Your Ref: OWPC15442
Our Ref: FG/135/17/PL 18-08-2017
Please ask for:
Mrs A Gardner

Erection of 1 no. 2 bed dwelling
South Point Beehive Lane Ferring

Thank you for your internet representation made on 3rd September 2017 which has been recorded as '**an objection**' with the comments as follows:

Proposed Block Site Plan - 1:200 @ A1

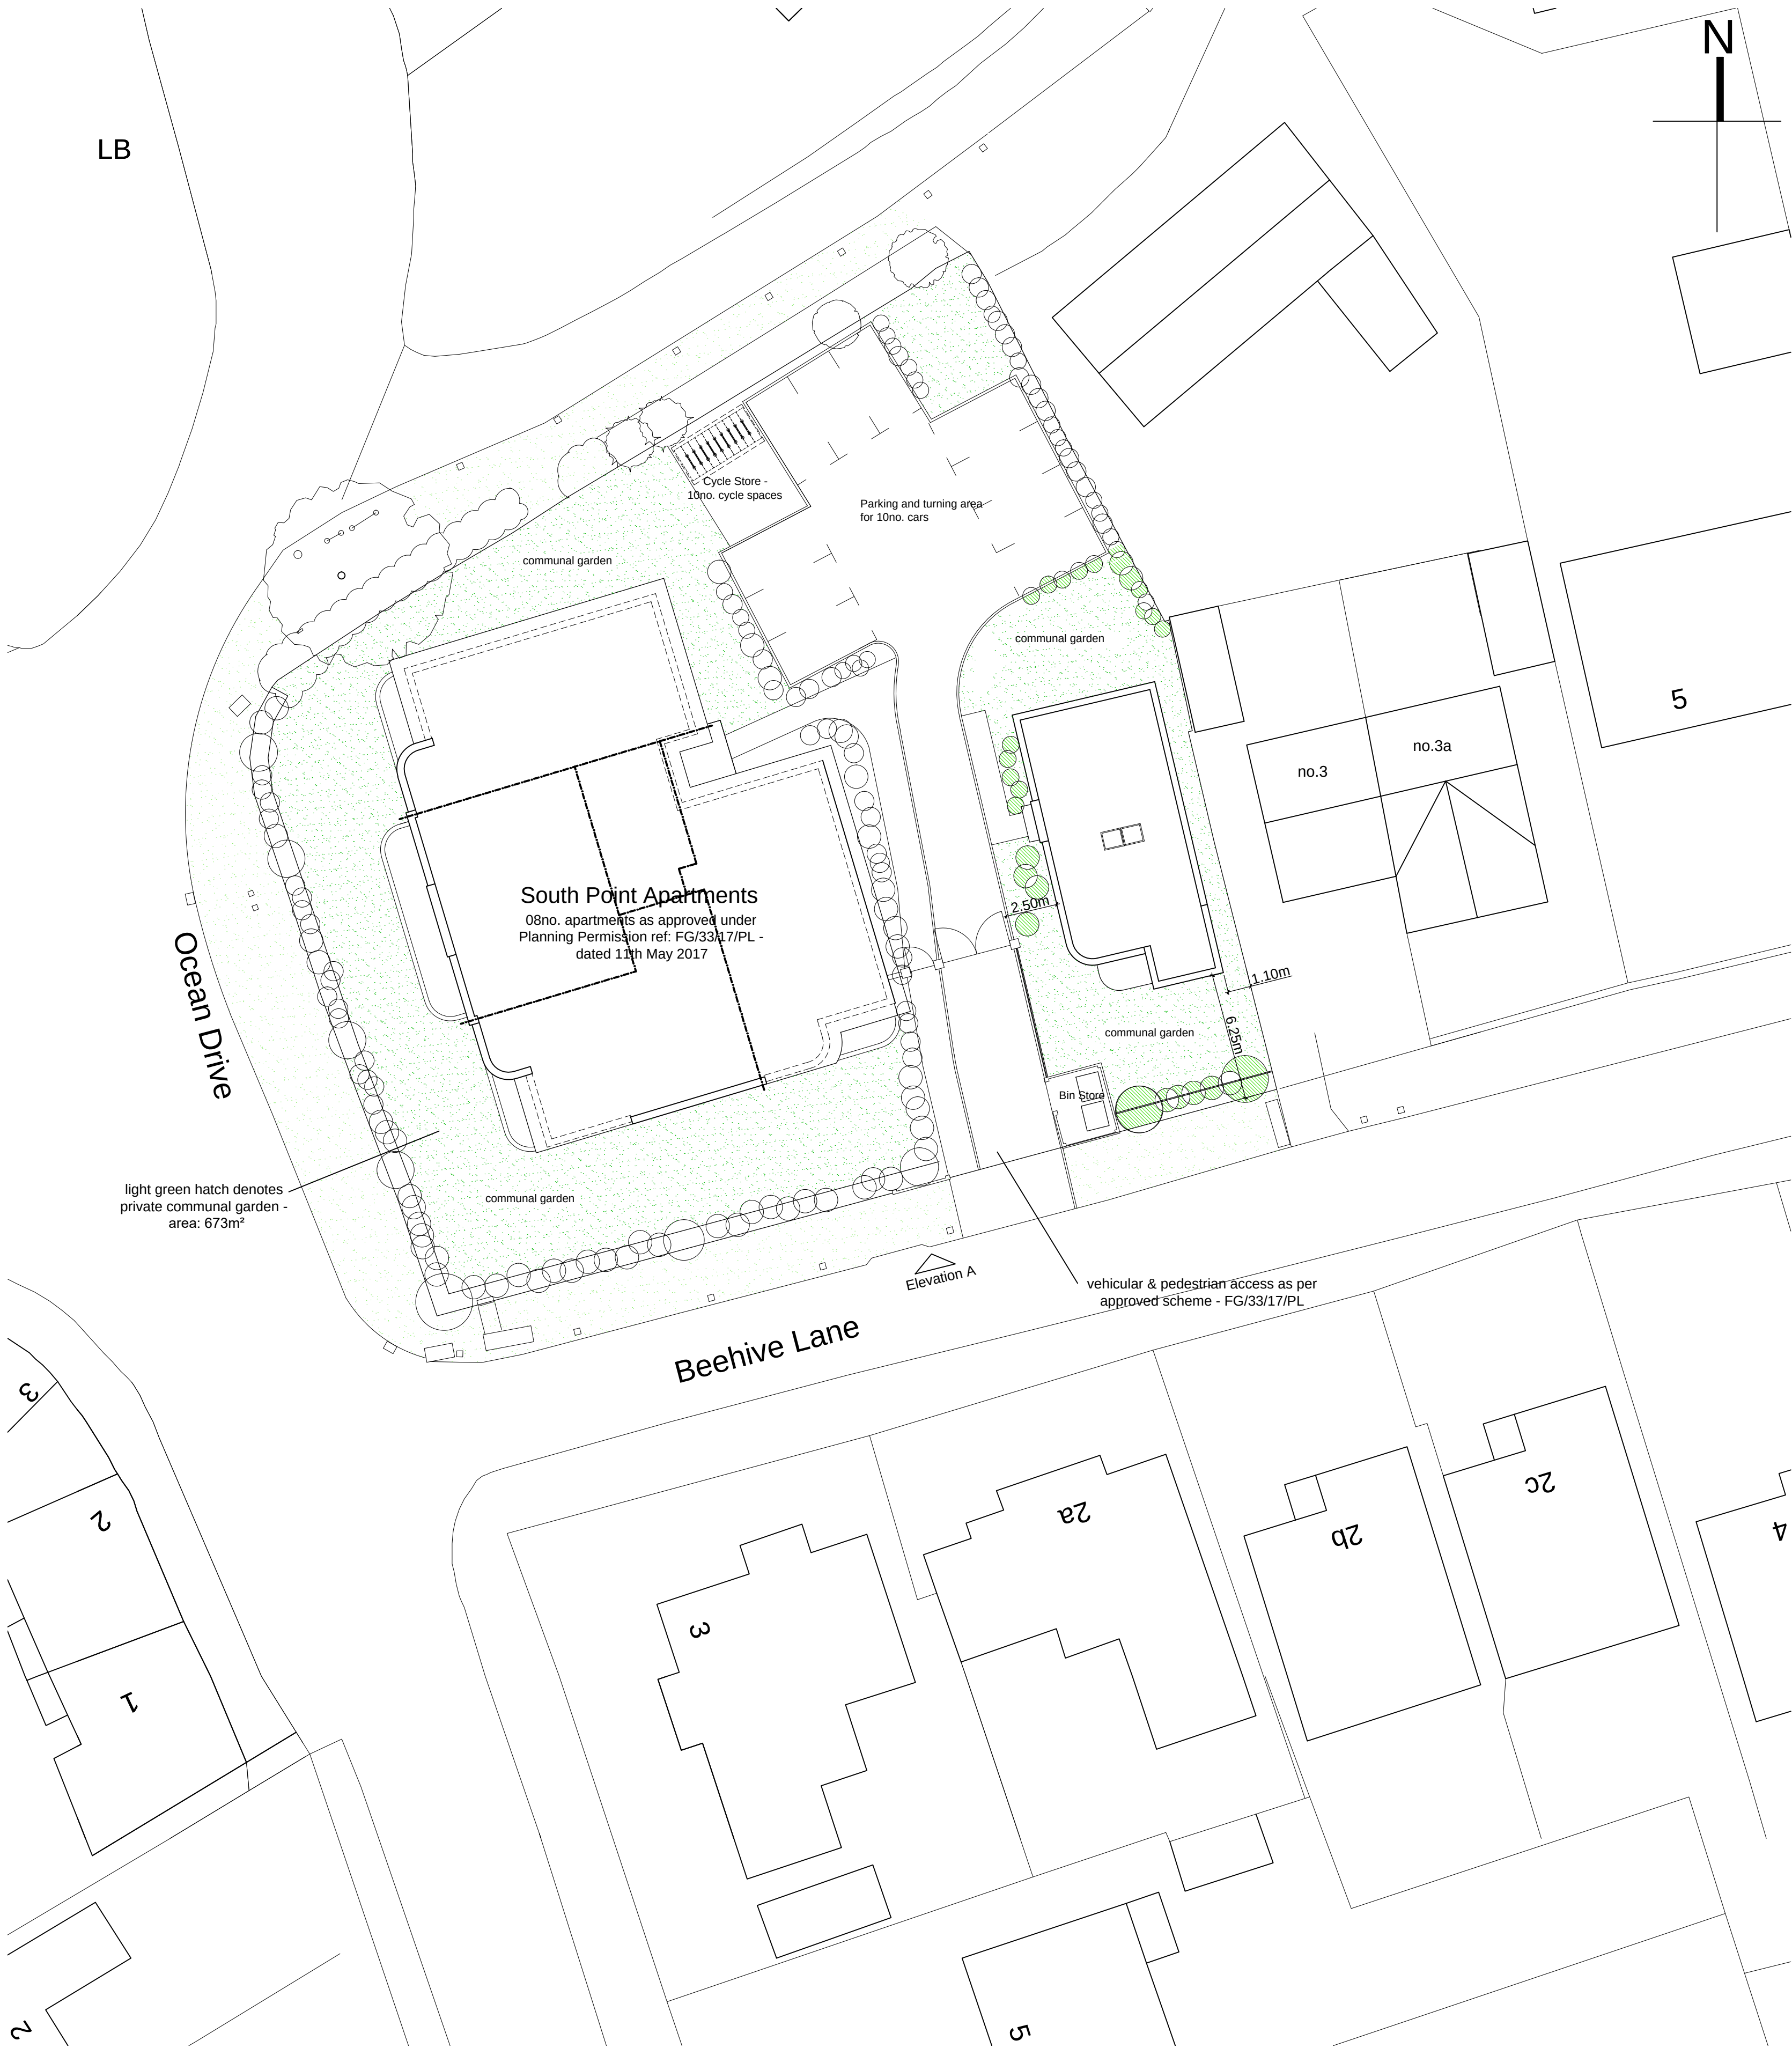
The proposal is a contradiction of the approved plans FG/186/16, FG/33/17 and FG/100/17, the implementation of which is now underway. In particular it is contrary to Condition 2 in each of the approvals, requiring the development to be built according to the plans submitted.

The provision of the community garden is essential to the amenity of the flats in the approved scheme. Moreover, the two schemes taken together would constitute overdevelopment, and be out of keeping with the surrounding area.
